Engineers Comments Regarding Surface Water Drainage

Application Reference:	AB/145/25/DOC	Reviewer Reference:	ADC/EXT4
Planning Officer:	Kathryn Welch	Date of Review:	09/01/2026
Site Name:	Electricity Sub Station And Gas Valve Compound Ford Road Arundel BN18 9FN		
Application Description:	Approval of details reserved by condition imposed under AB/88/19/PL relating to condition 4-as built drawings concerning drainage.		
Assessment Number:	1 of 2

Response	Condition 4 – As built drawings concerning drainage: Further information required
-----------------	--

Drawing No. 8150432/4100

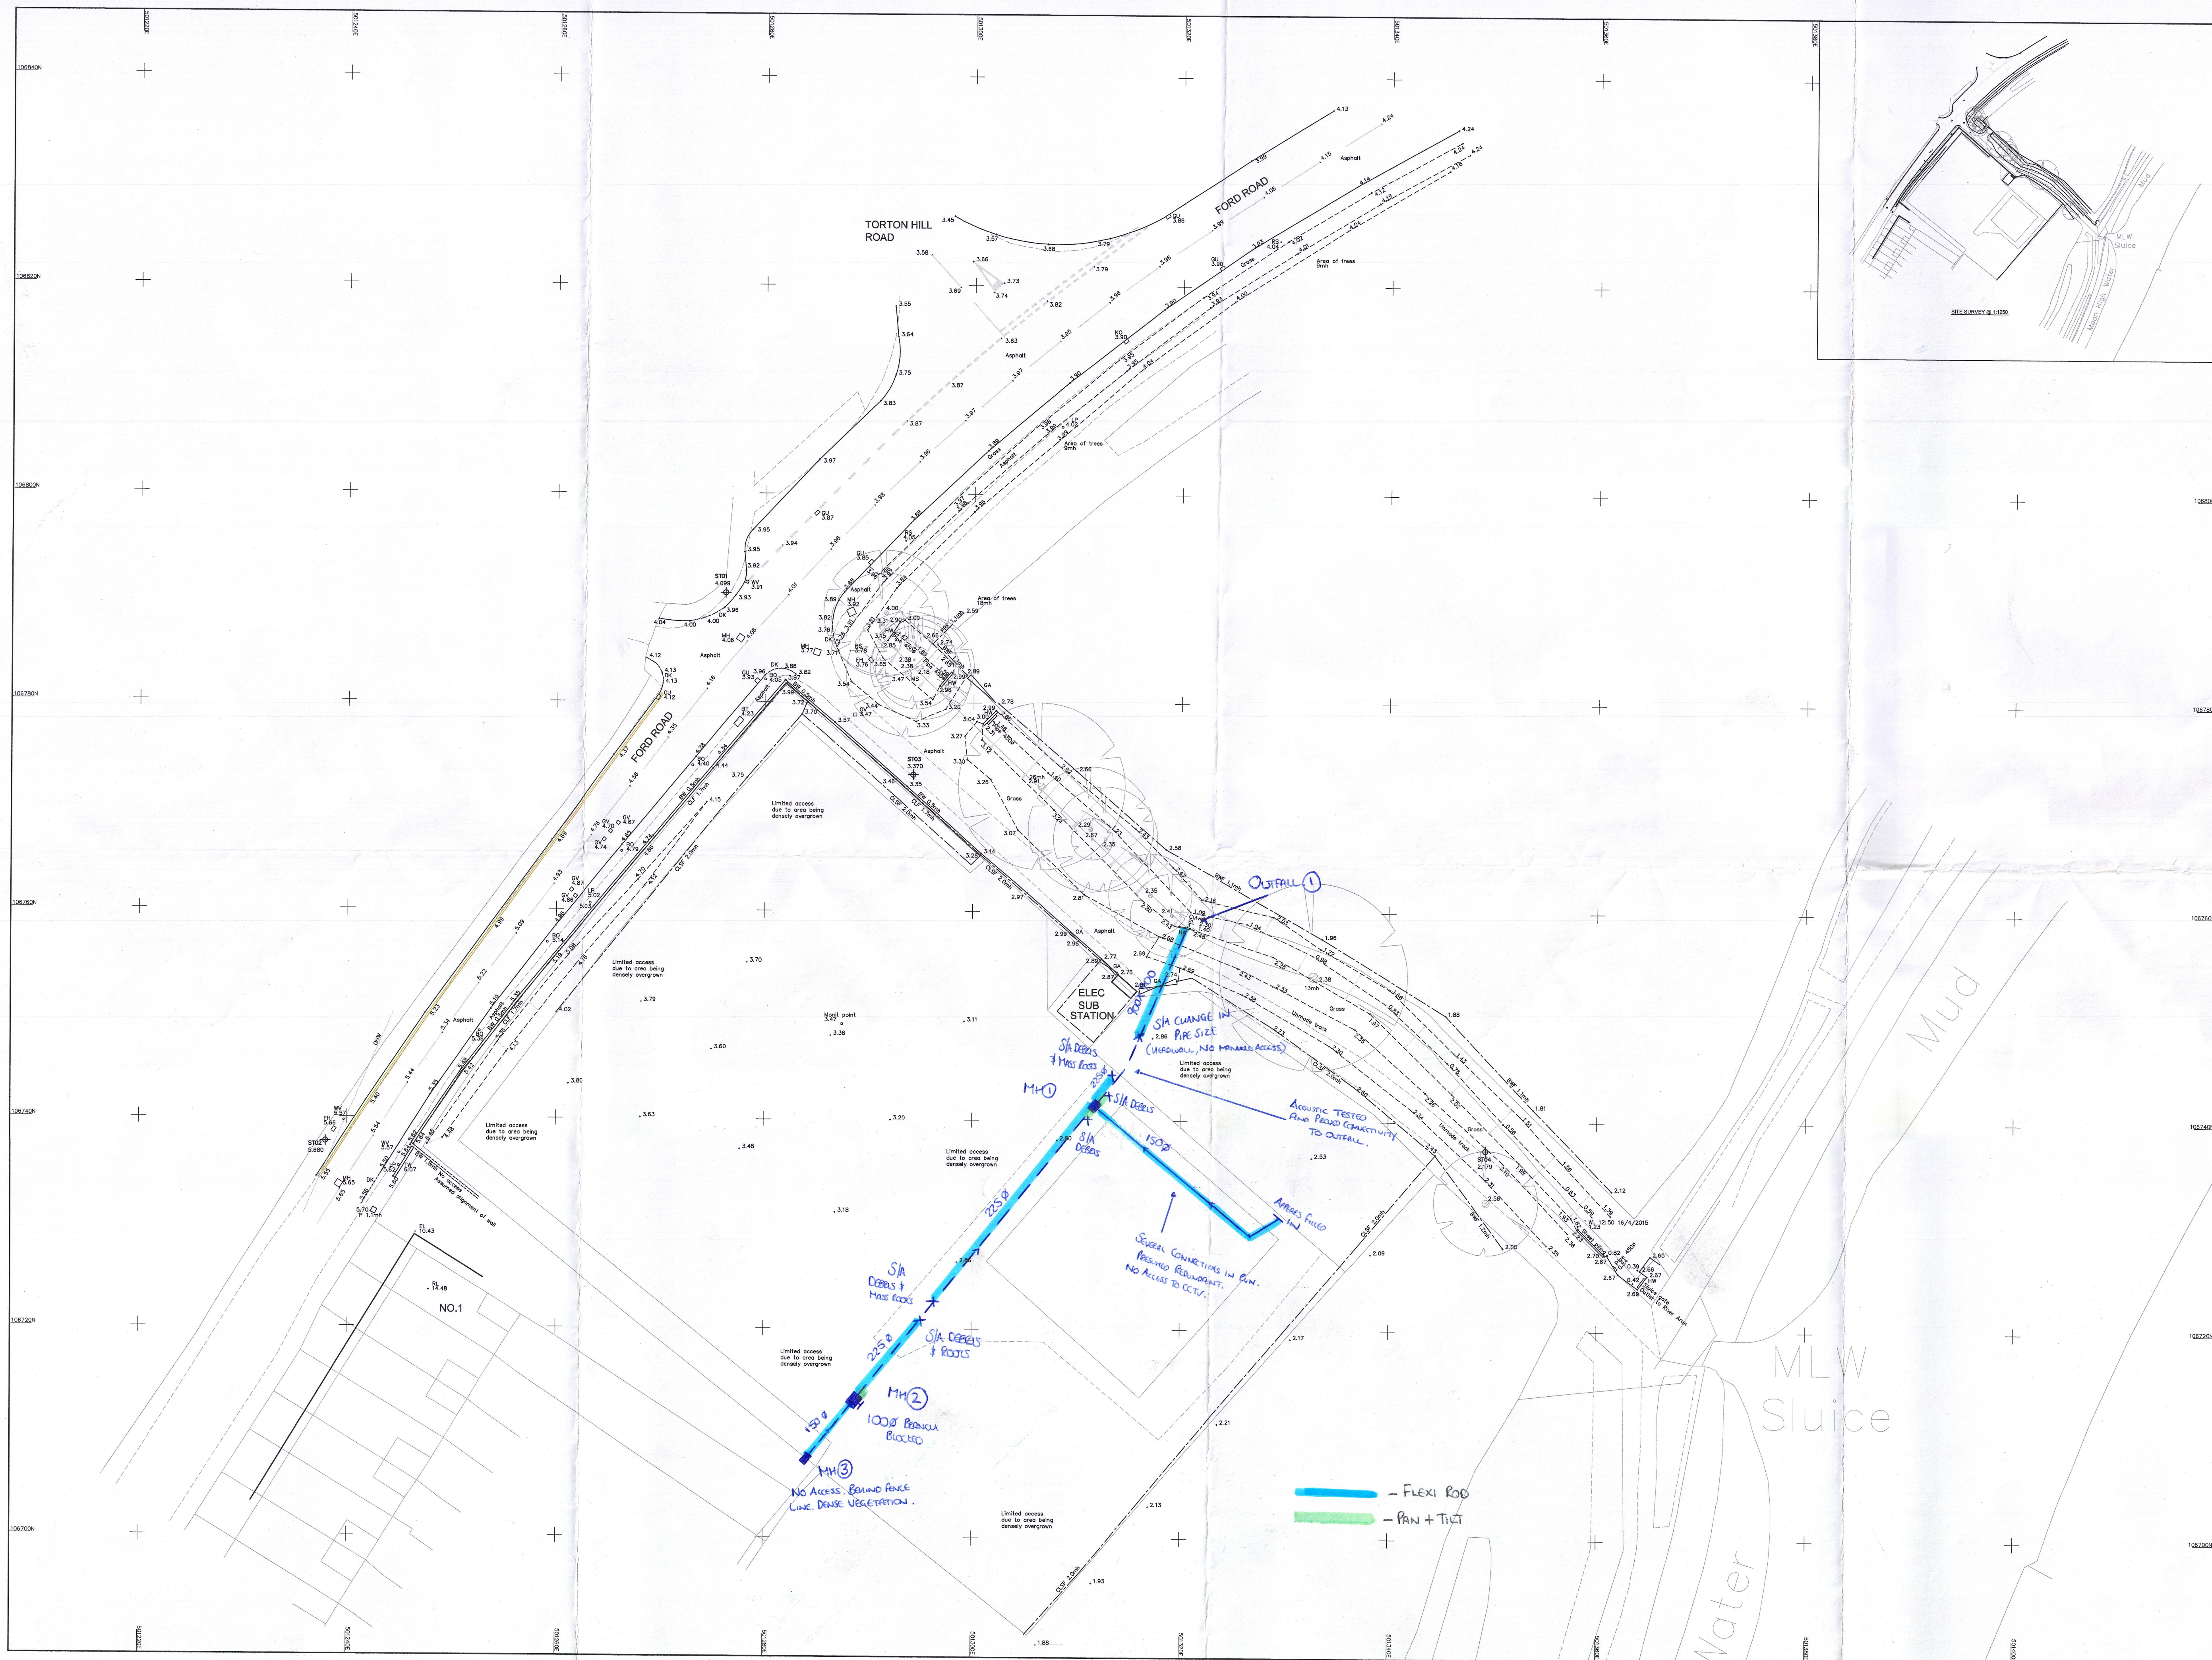
3.	Provide an as-built survey of the installed main principle surface water drainage network.				
4.	Provide CCTV survey of the principle surface water drainage.				
5.	Some of the approved plans submitted and used to inform this application do not align with those listed on the decision notice for application AB/142/22/DOC, some are not included at all. Where there are changes in the design from that originally approved these should be explained. If any changes are significant a new application to discharge condition 3 may be required.				
6.	Please submit full construction detail drawings and verification of the bespoke above ground storage tanks. It was an explicit expectation on the decision notice for application AB/142/22/DOC that these details would be submitted to support discharge of condition 4.
